CITY OF ALBUQUERQUE

**RE: 8500 Glendale Ave NE
Reclamation Plan
Engineer's Stamp Date: 01/22/19
Engineer's Certification Date: 02/08/19
Hydrology File: B20D067**

As a reminder, your November 13, 2018 submittal for Building Permit, based upon the information provided this Grading Plan **was not** approved for Building Permit. The following comments need to be addressed for approval of the above referenced project:

ENGINEER'S SEAL 11/10/18 DAVID SOULE P.E. #14522	8500 GLENDALE AVE.	DRAWN BY DEM
	GRADING AND DRAINAGE PLAN	DATE 11-9-18
	 Rio Grande Engineering 1808 CENTRAL AVENUE SUITE 201 ALBUQUERQUE, NM 87108 (505) 872-0888	LOT 5, BLOCK 17 ON 3 INJUNCTION
		SHEET # 1 OF 1
		JOB # XXXXX

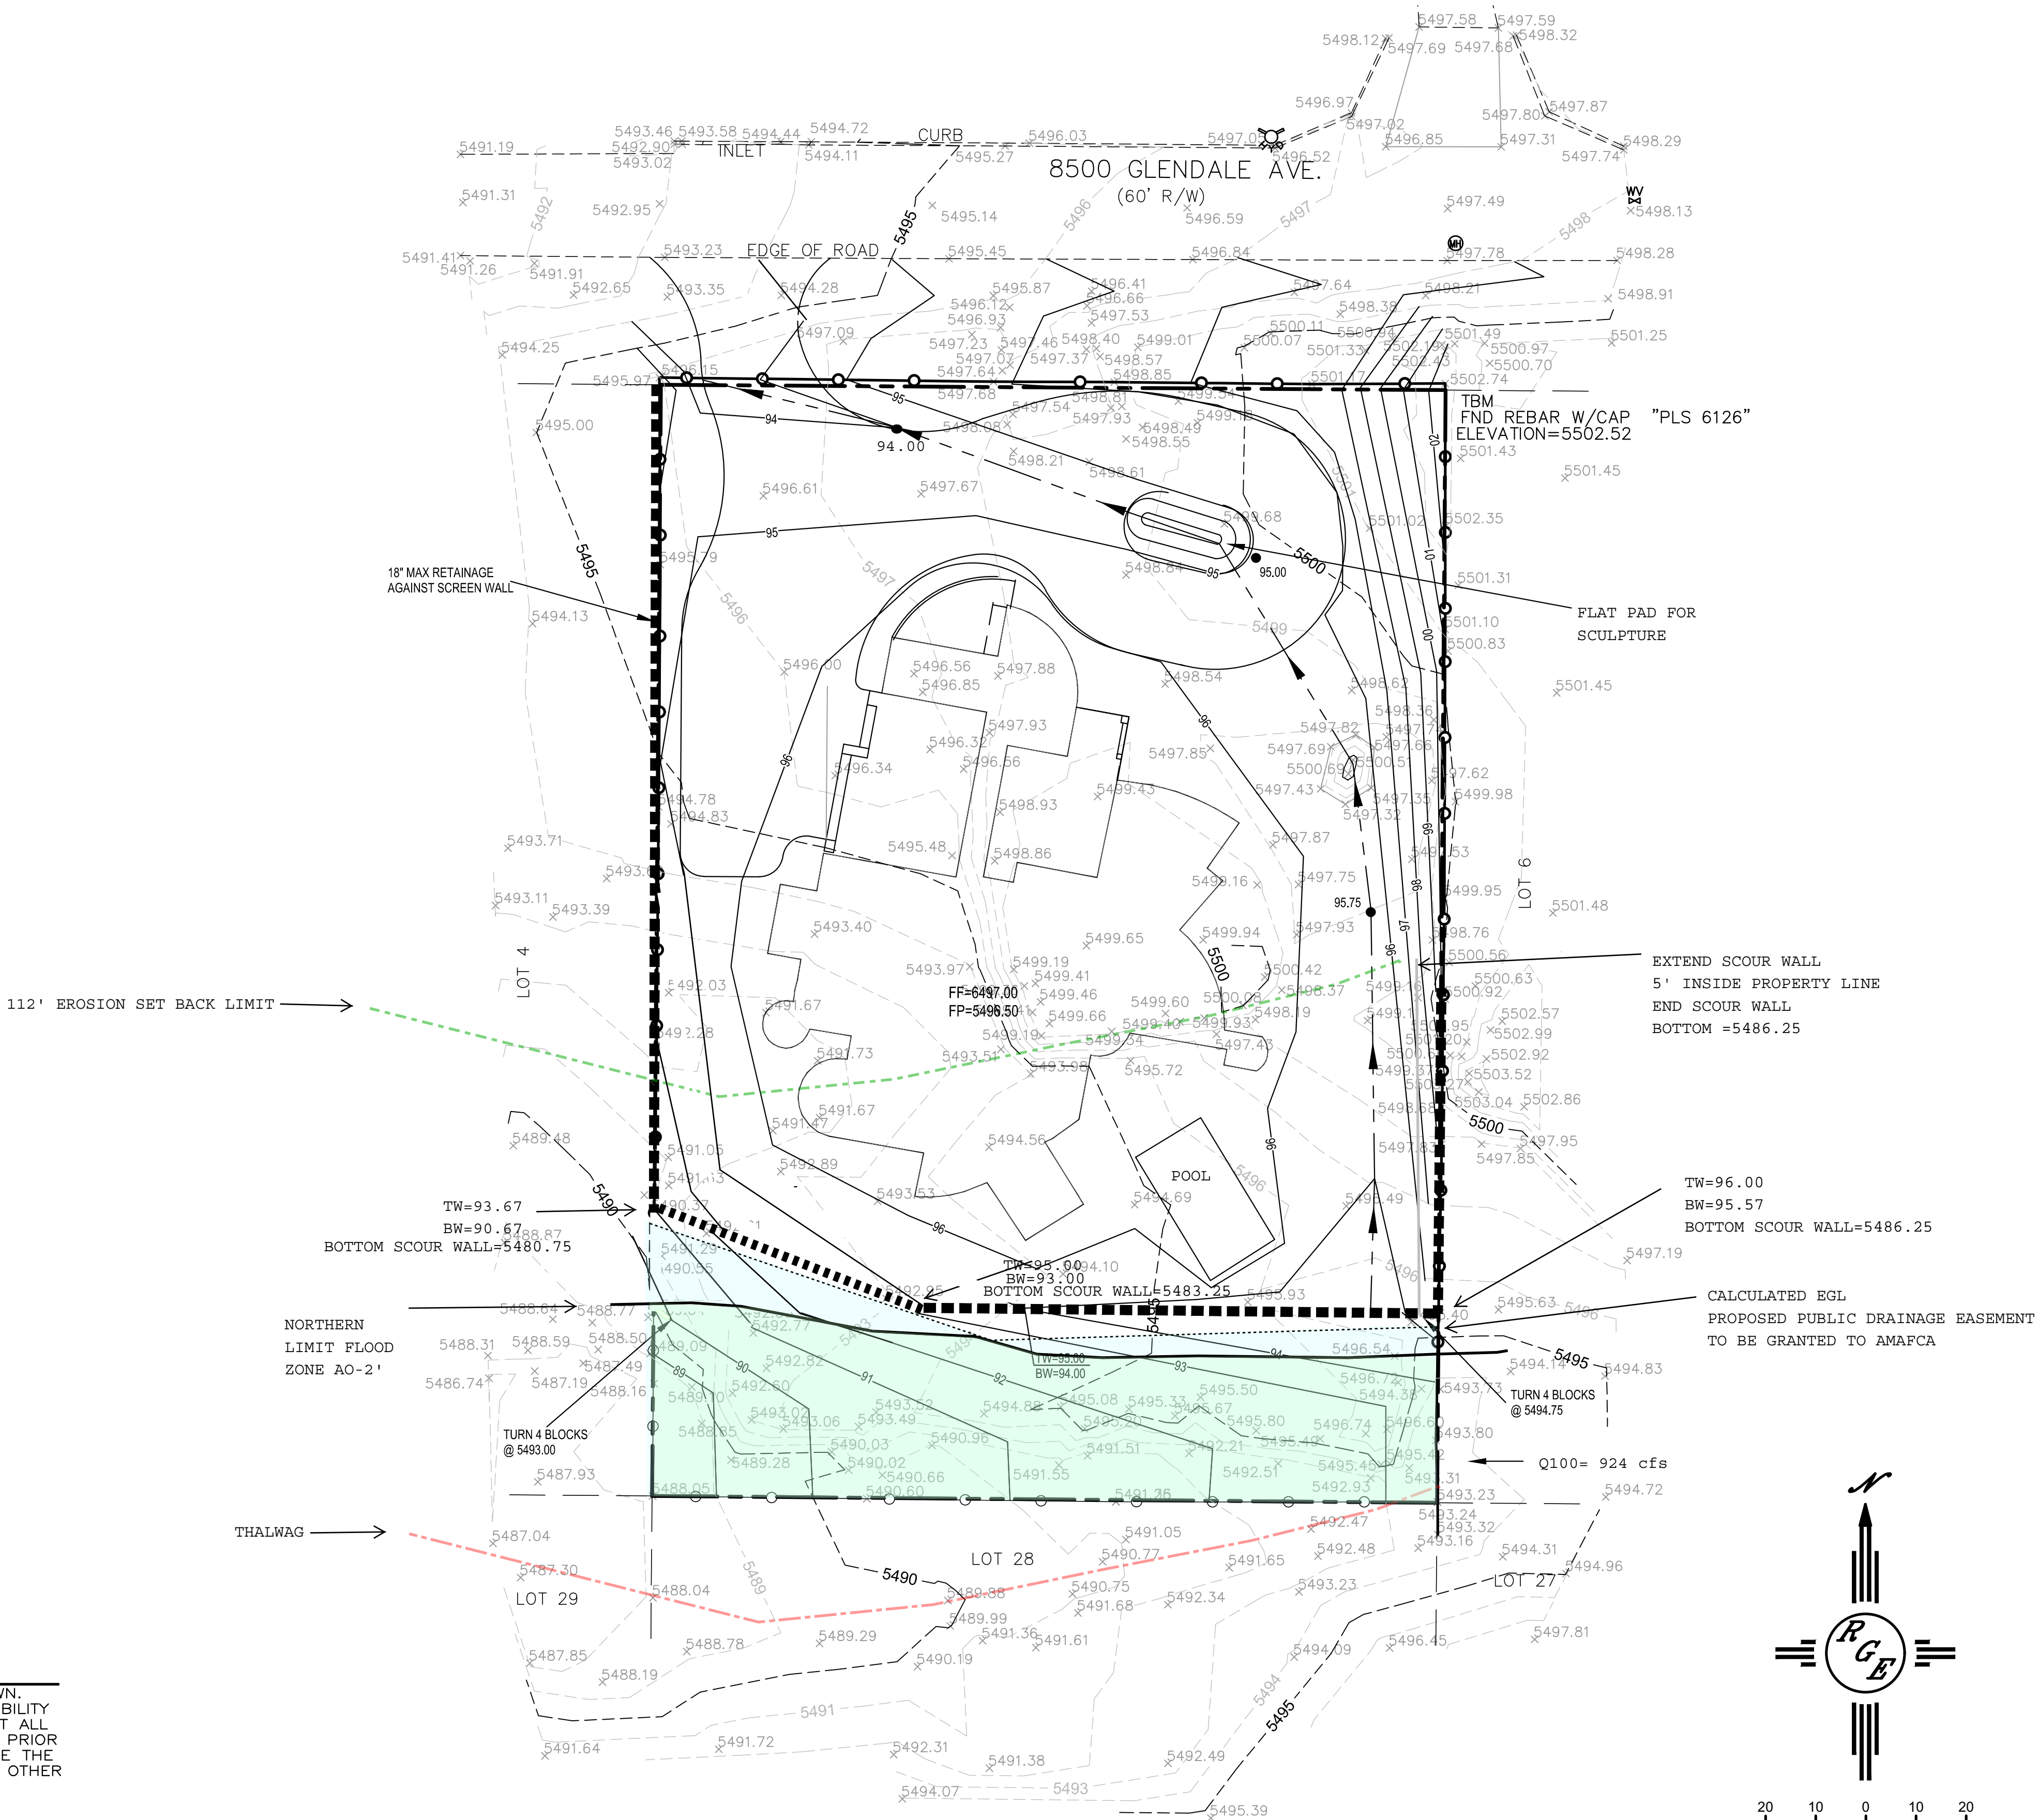
2. Please add a drainage easement along the 100 year floodplain line granted to the City. The Permanent Easement form can be obtained at the Hydrology Section's webpage. <https://www.cabq.gov/planning/development-review-services/hydrology-section>

3. Please clarify the finished floor elevation and finished pad elevation. They are currently over the existing grade text and it is difficult to read.

4. Please provide the sections and structural calculations of the scour walls.
5. Please clarify the placement of the leader for the turn 4 blocks @ 5493.00 near the southwest corner of the property. It is currently pointing in the arroyo and not the scour wall.

6. Please provide an additional scour depth equation (3.90 in the Sediment and Erosion Design Guide) for flows at a 90° to the scour wall. The current scour depth equation is only good for flows parallel to the scour wall. This will increase the scour wall depth in the areas where flows are at 90° to it.
